City of Albuquerque Stormwater Construction Site Inspection Report

Project Name:		Defined Fitness @ Unser Crossings					
Location:		Unser & Central					
Site Contact Name & Agency	Joseph - Blanchard Properties			ESC File No.	K10E045B		
	rjones@jonescpa.com			NPDES Id. No.	NMR1001X7		
Inspection Date:	07/10/19	Start/End Time:	0830/0900hrs				
CoA Stormwater Inspector:		Timothy E. Sims					
Construction Phase:		foundation and plumbing					
Type of Inspection:	x	Regular	Storm Event	Post Storm Event >0.25"	311/Complaint	Follow Up

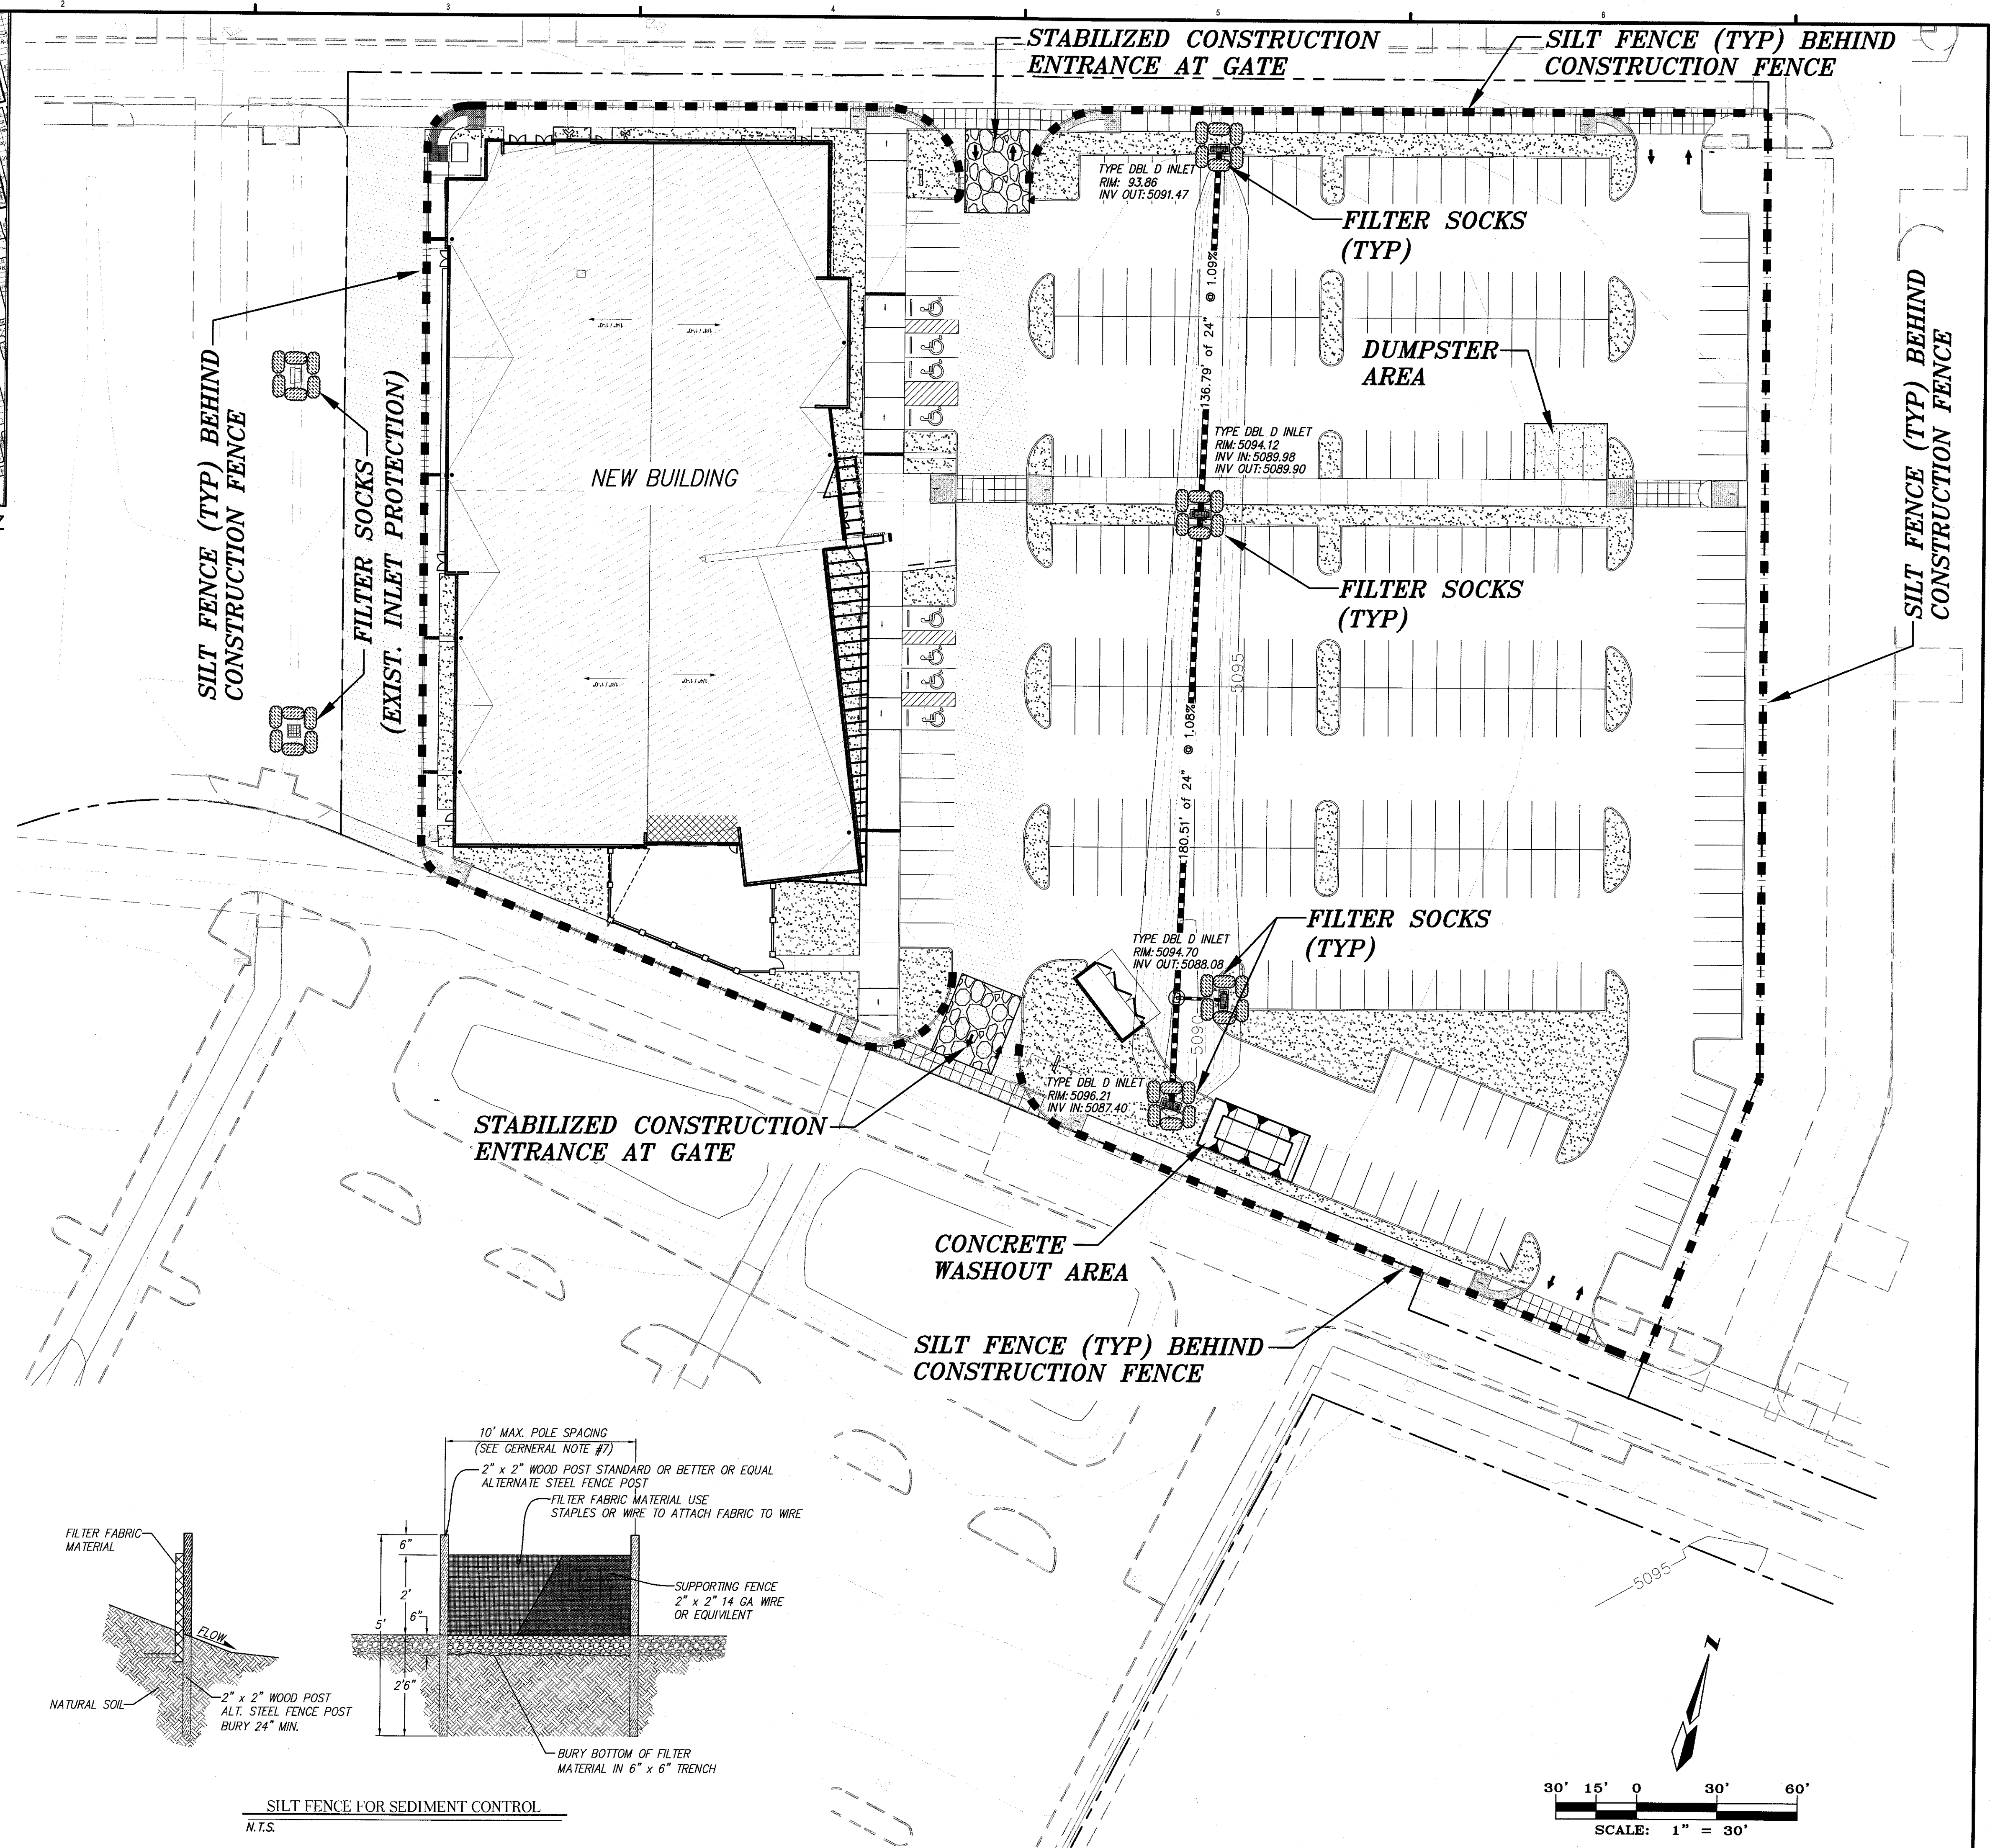
Item Number	Deficiency/ Corrective Action		
1	Please re-establish silt fence in the southwest corner of the site		
2.1	Discharge off site? (Y/N)	No	
4	Self Inspection Reports		Latest report Date: 7/3/2019
